Please ask for: Mrs D Johnson
Email: daun.johnson@arun.gov.uk
Telephone: 01903 737762
Our Ref: LU/67/20/PL
Your Ref:
Date: 19th March 2020

Application for Planning Permission

Development: Replacement of 2 No. windows & 1 No. door with PVCu Heritage Flush type to rear elevation. This application affects the character & appearance of the Littlehampton Seafront Conservation Area.
Location: Second Floor Flat 37c South Terrace Littlehampton BN17 5NU

Proposed East Elevation of Rear Outrigger - 1/100

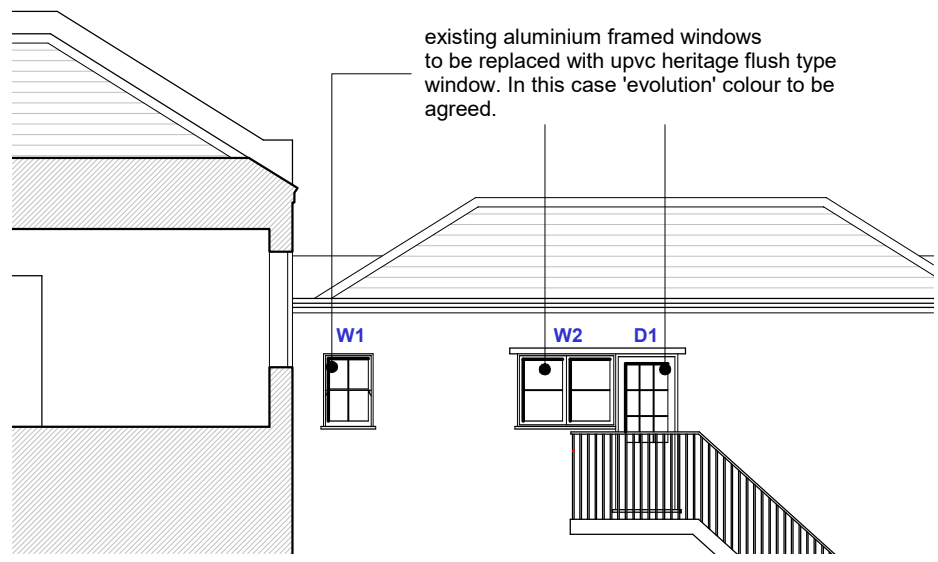
Please clearly highlight the two windows and one door that are being replaced.
CIL Additional Information Form
